**WELWYN HATFIELD BOROUGH COUNCIL
ASSISTANT DIRECTOR (PLANNING)**

DELEGATED APPLICATION

Application No: 6/2023/2321/FULL
Location: Cuffley Gate Sopers Road Cuffley Potters Bar EN6 4RY
Proposal: Erection of a new steel structure canopy (sheltering) for ventilation and storing goods for the manufacturing process and extension to existing sheltering by the west block for ventilation and storing goods for the manufacturing process
Officer: Ms Elizabeth Mugova

Recommendation: Granted

PROPOSED ROOF PLANS

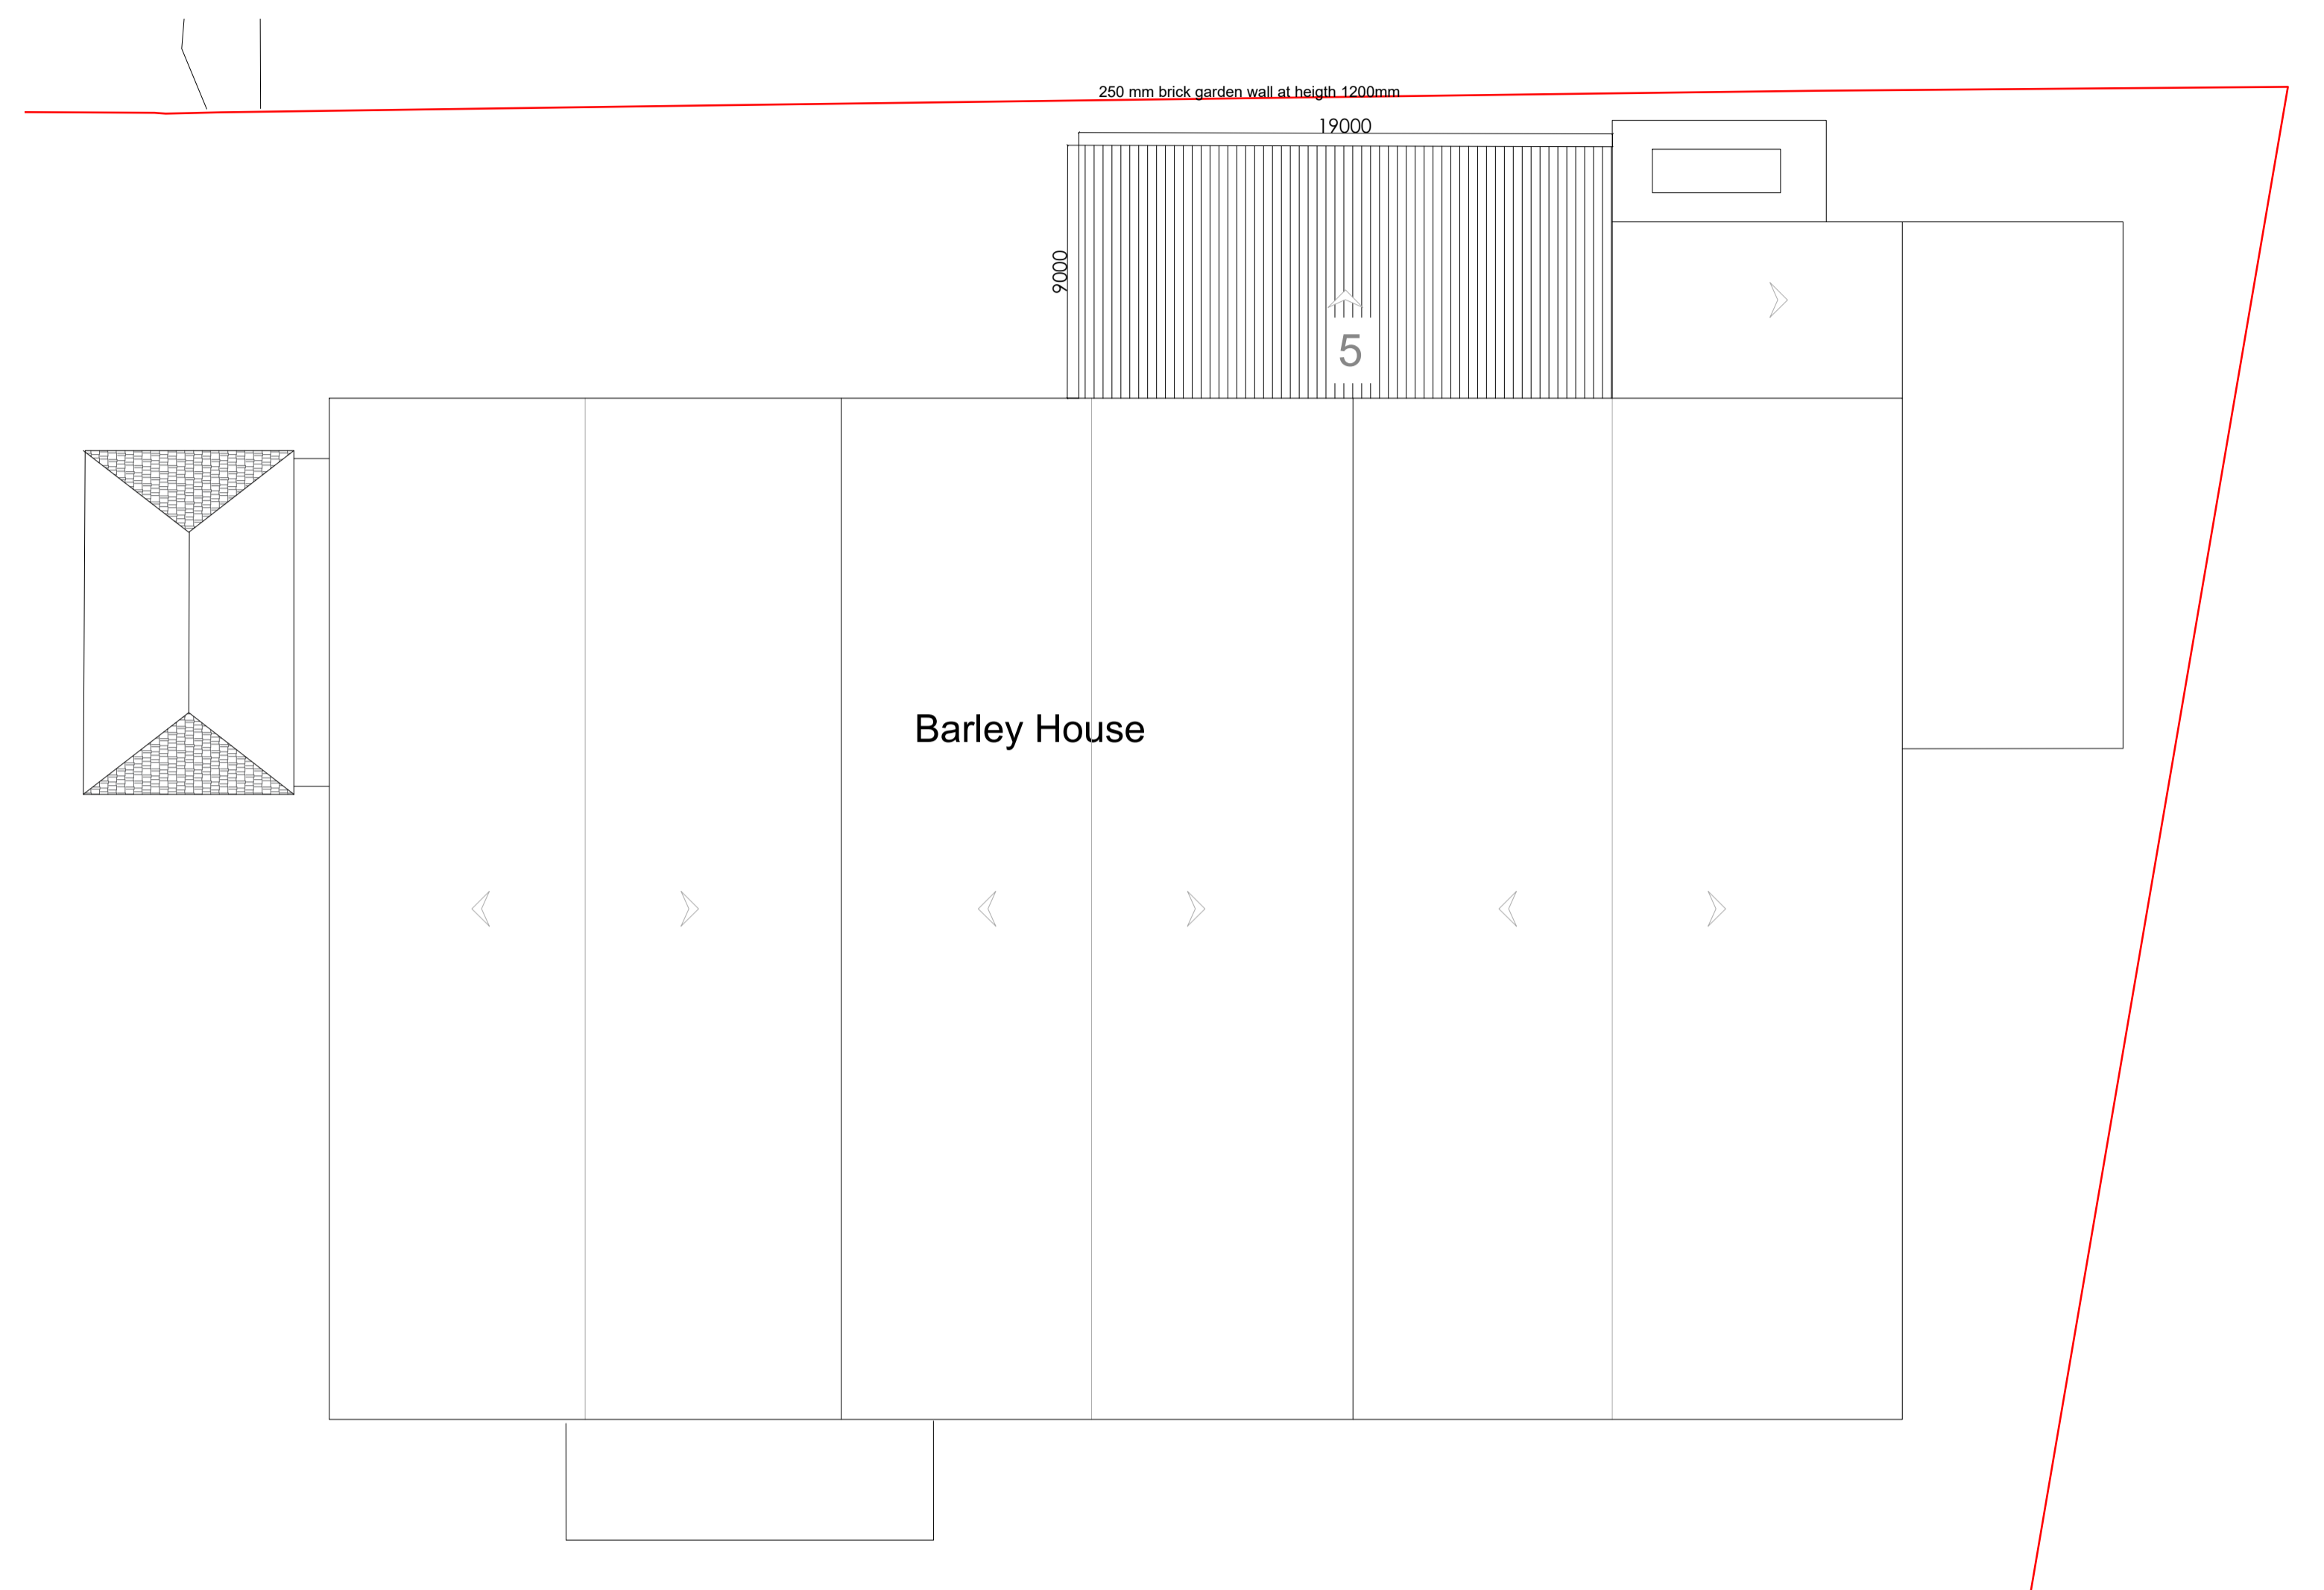
<p>The proposal includes an extension to the existing sheltering next to the MIR PAC building for ventilation and storing goods for the manufacturing process. This element of the proposal would be sited along the boundary with Media House where there are windows serving offices on the ground and first floor. The height of the structure would be retained and there would be a gap of approximately 5 metres between the boundary wall and flank wall of the neighbouring building. With regards to the structure canopy next to Barley House, it would be located adjacent to containers sited at the recycling centre next door. It is considered that the height, scale and siting of both structures would not appear dominant and prominent within the surrounding industrial estate.</p> <p>The structures would be finished in metal cladding sheets. External materials can be secured via a condition. It is considered that the design of the structures is acceptable in this location.</p> <p>Overall, the proposed development would not adversely affect the character and appearance of the existing buildings and surrounding area. Accordingly, this proposal accords with local and national policies.</p>
